Department of Transportation

June 18, 2020

RE: Liberty Tree Academy Site Dev Plan - PPR2018

Memorandum

HCM 6th TWSC  
1: Eastonville Rd & Motley Rd/Liberty Tree

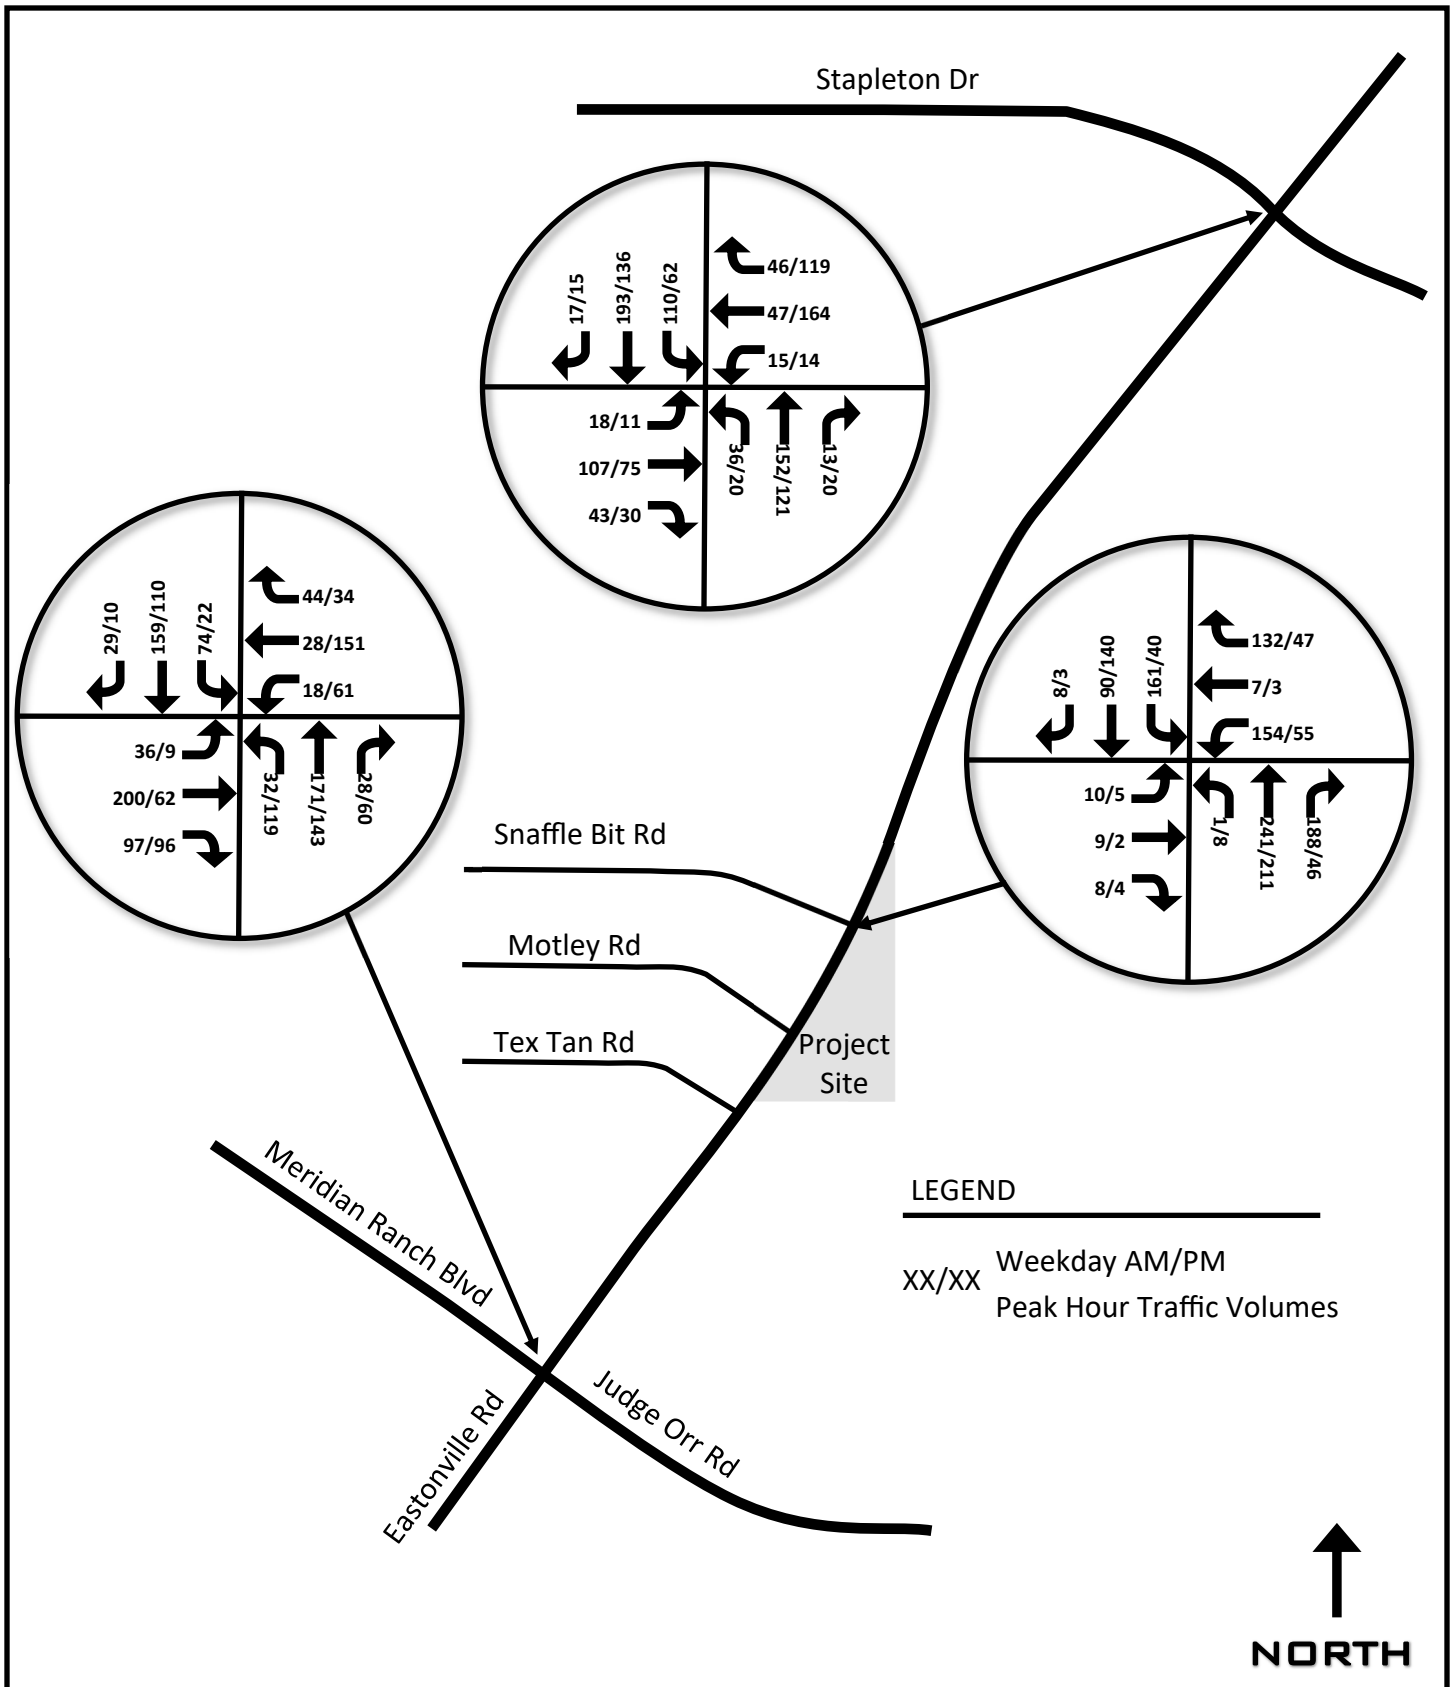
Please provide an exhibit of this phase 2 circulation plan.
